The Planning Department
Arun Civic Centre
Maltravers Road
Littlehampton
West Sussex
BN17 5LF

1 October 2012

**Planning Application – 65 Golden Avenue, East Preston, BN16 1QU
Reference K-15-12**

Drawing Title
FIRST FLOOR PLAN
and
CROSS SECTIONS

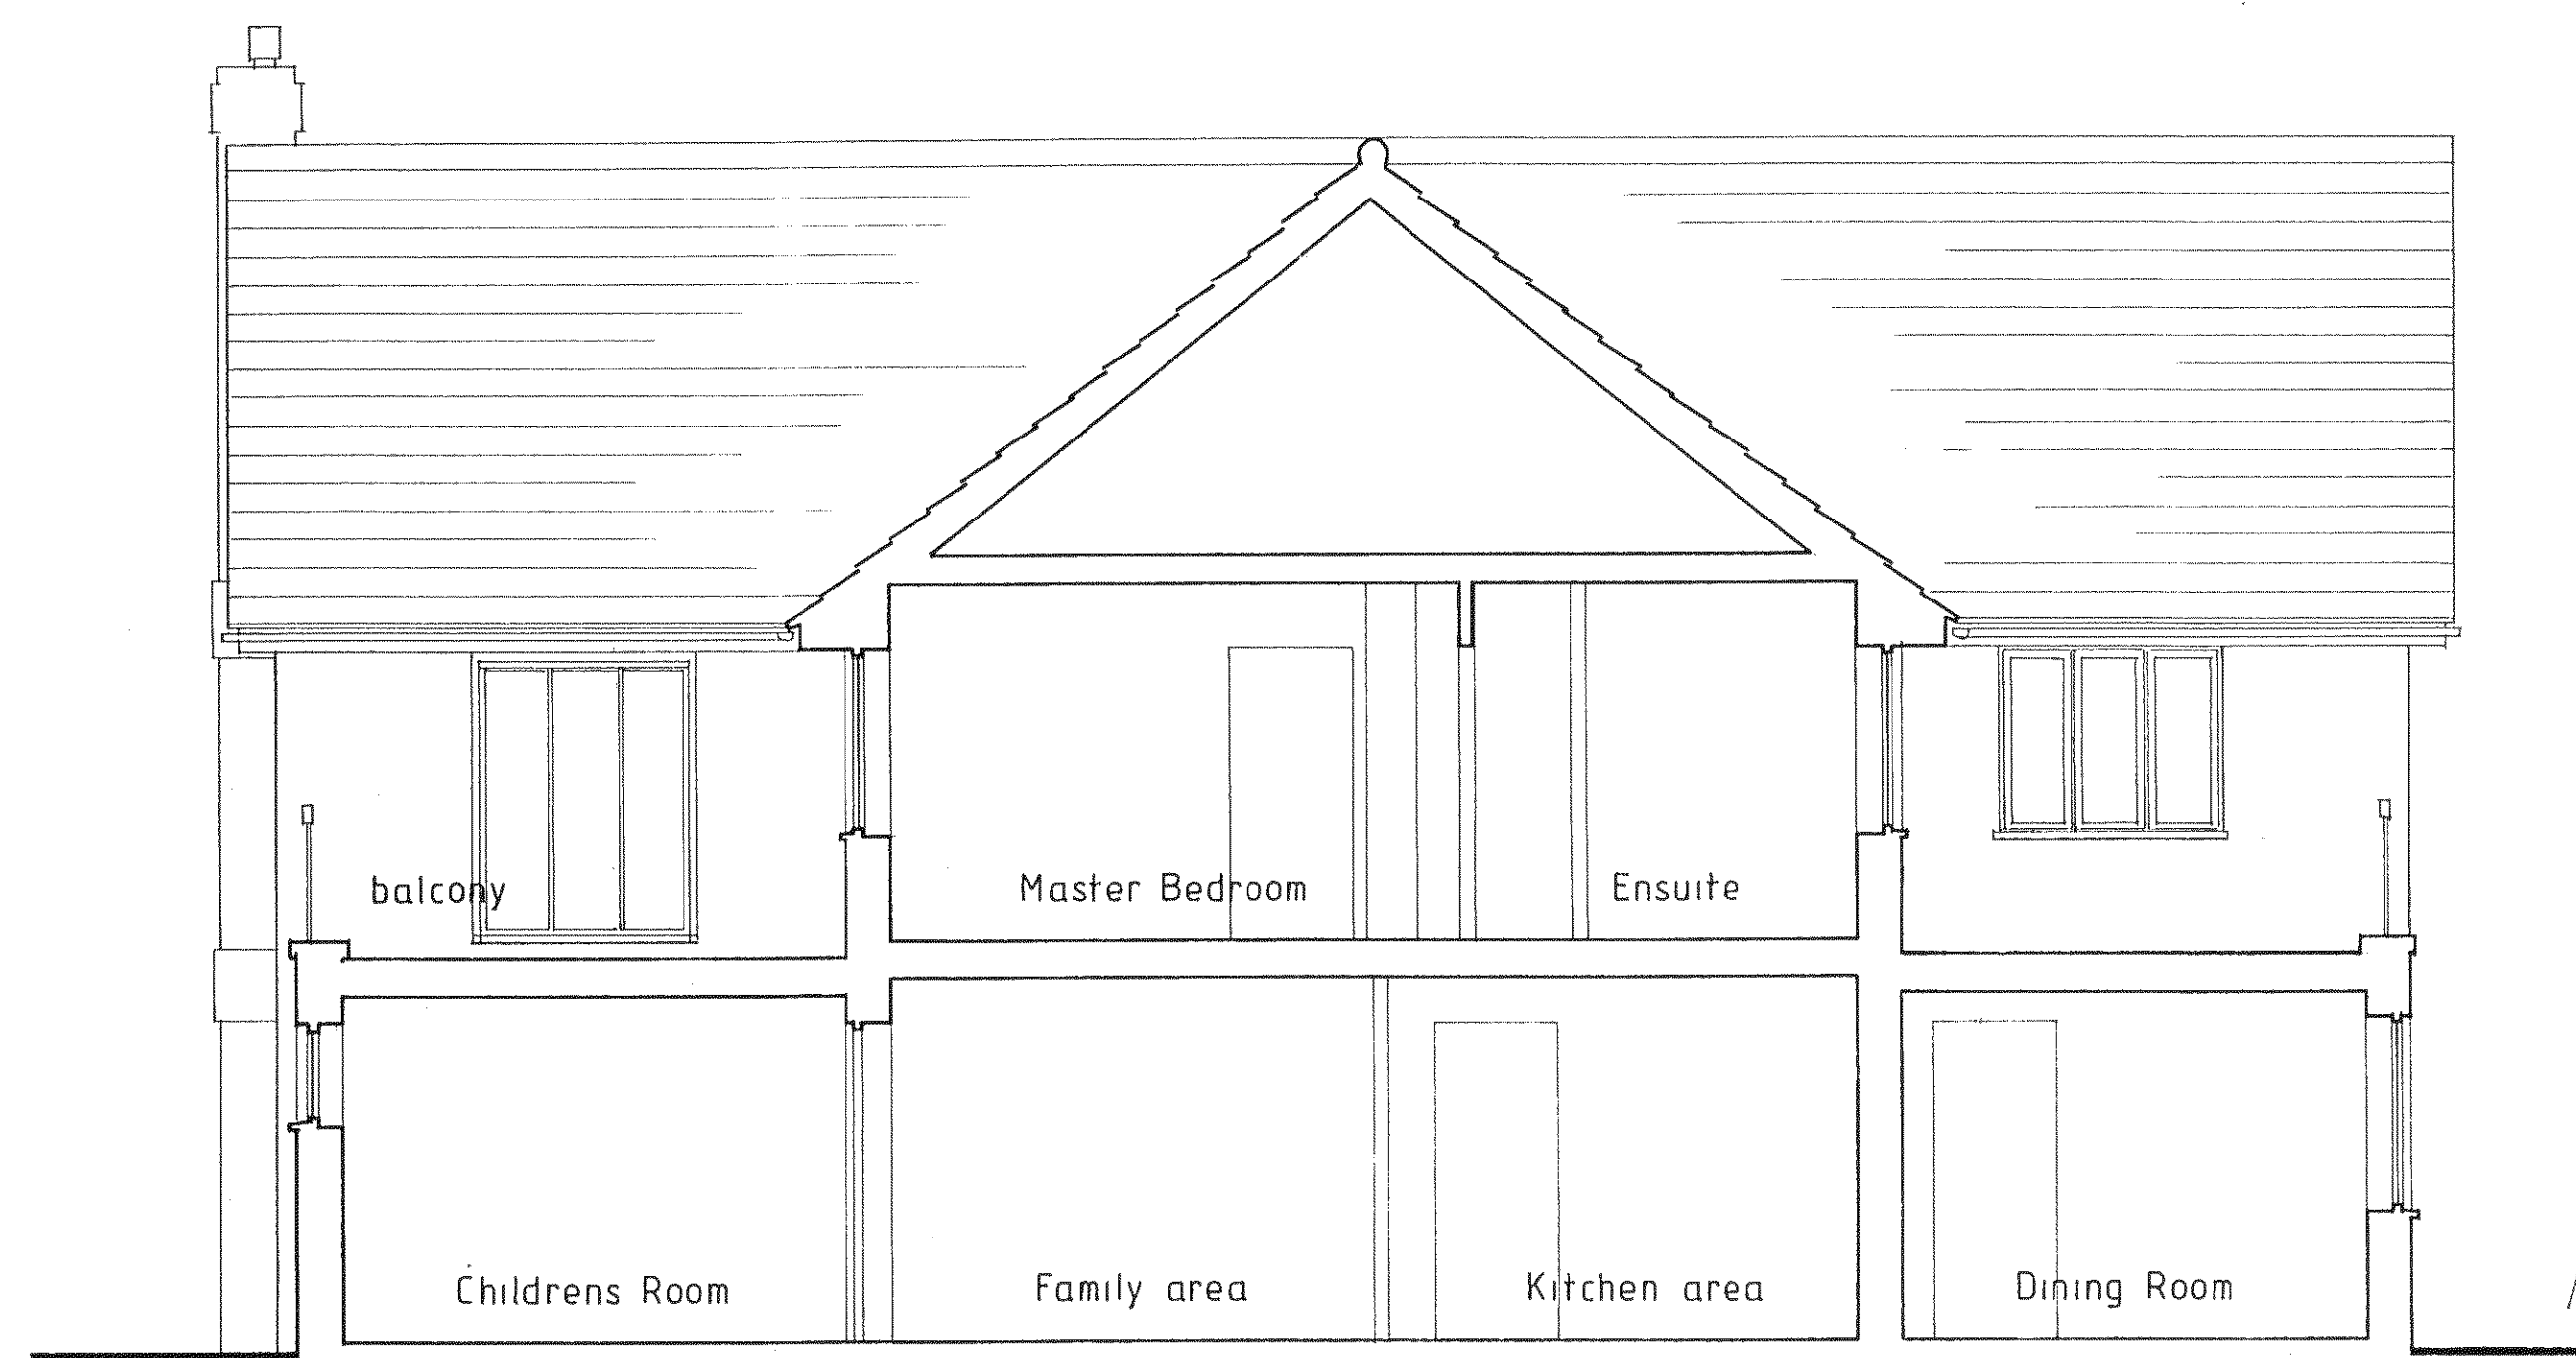
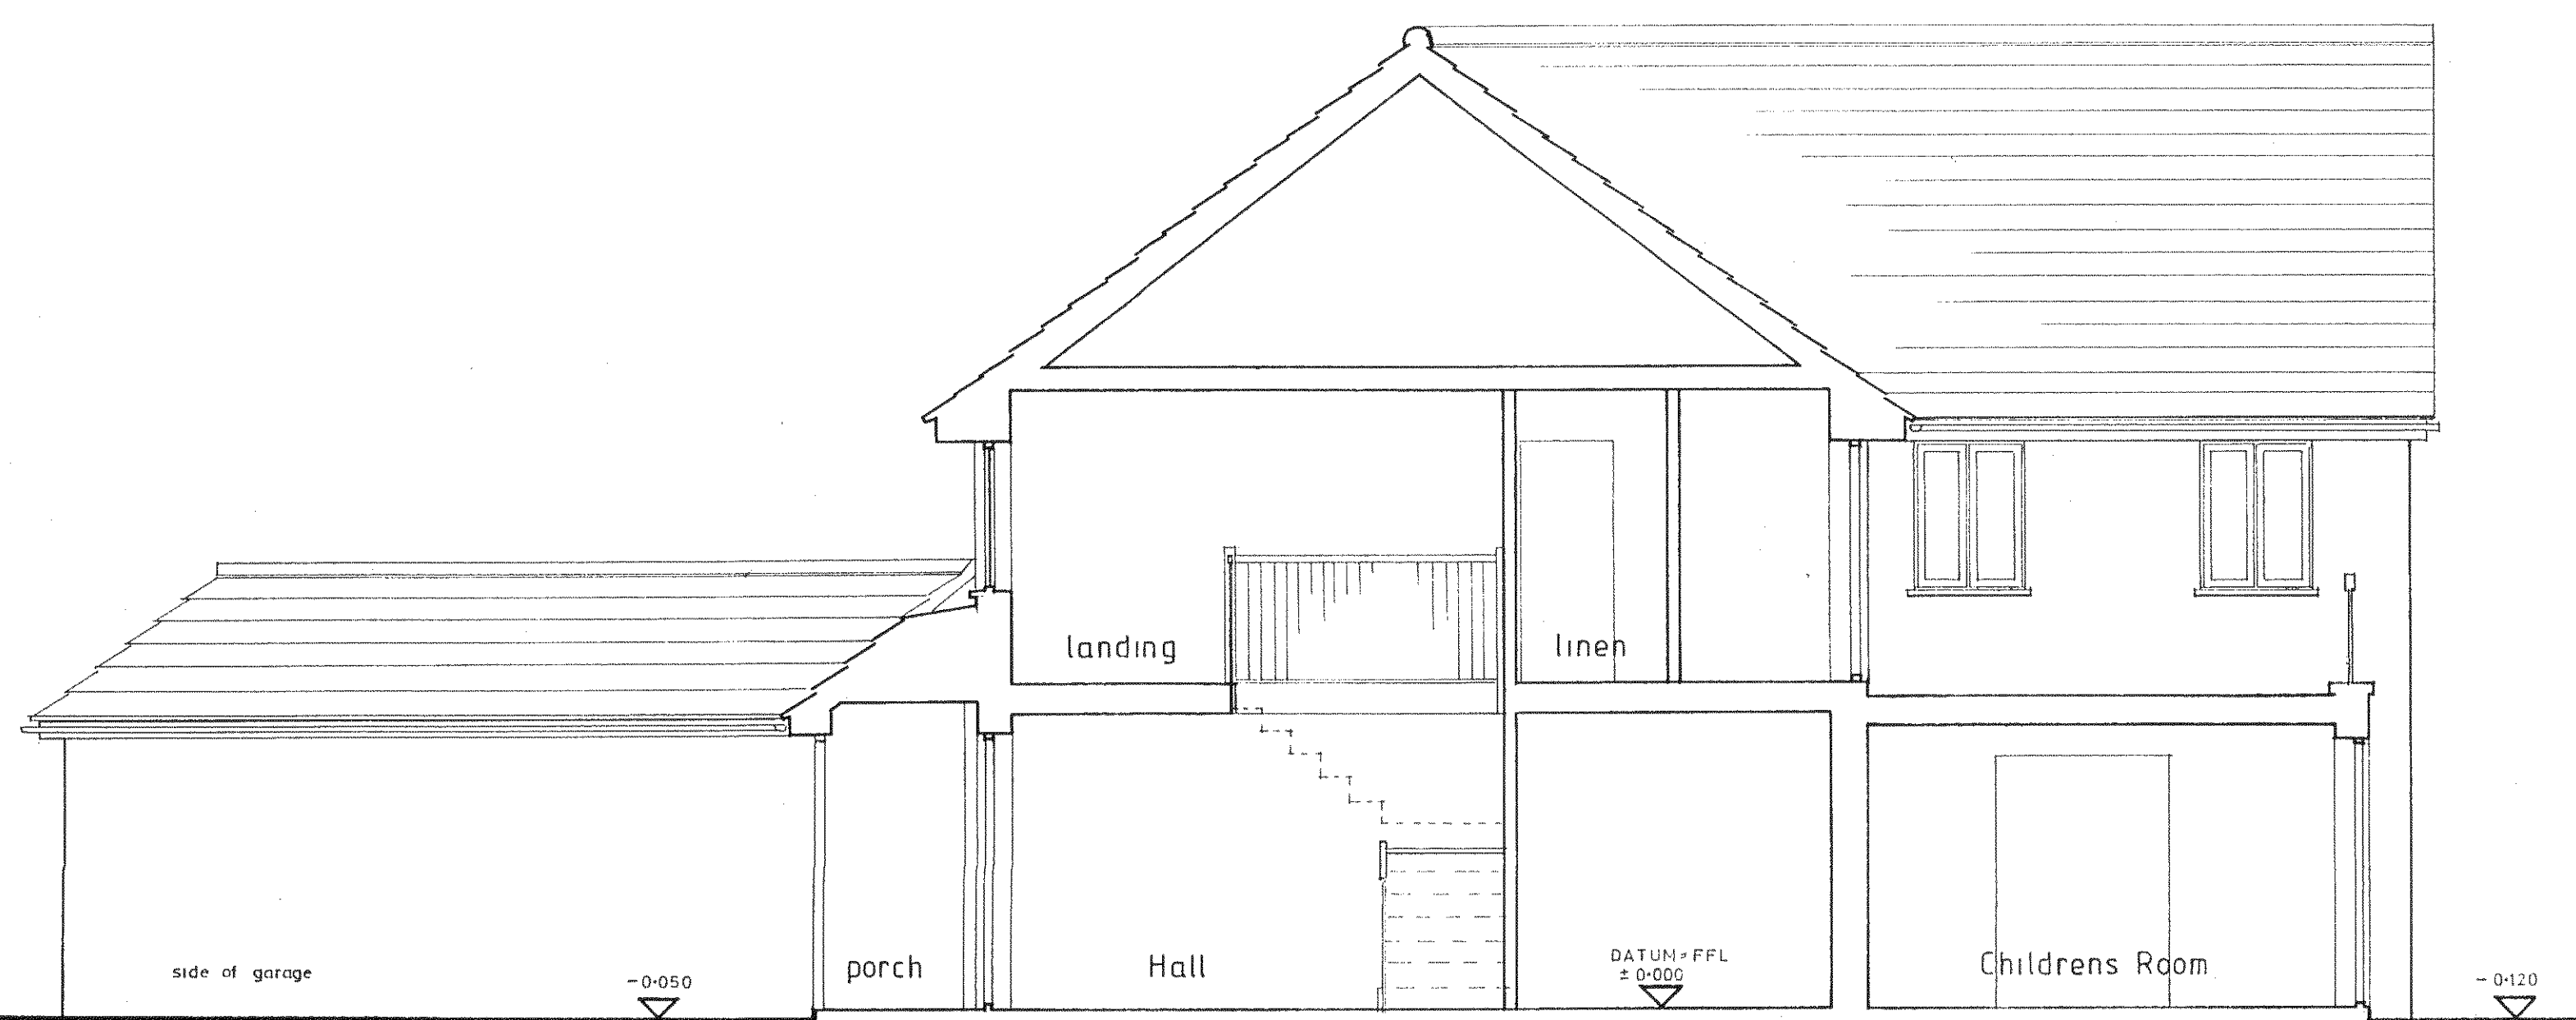
Whilst we do not oppose the planning application to the above property, we would like the windows that face south on the proposed balcony (from what we understand to be the principal bedroom), to either be replaced with a high level window(s) or the windows to be opaque glass.

These windows, we believe, will look directly down into our conservatory where we spend a lot of time all year round.

We could say the same about the proposed balcony but, in practice, we do not envisage that the balcony will be used much.
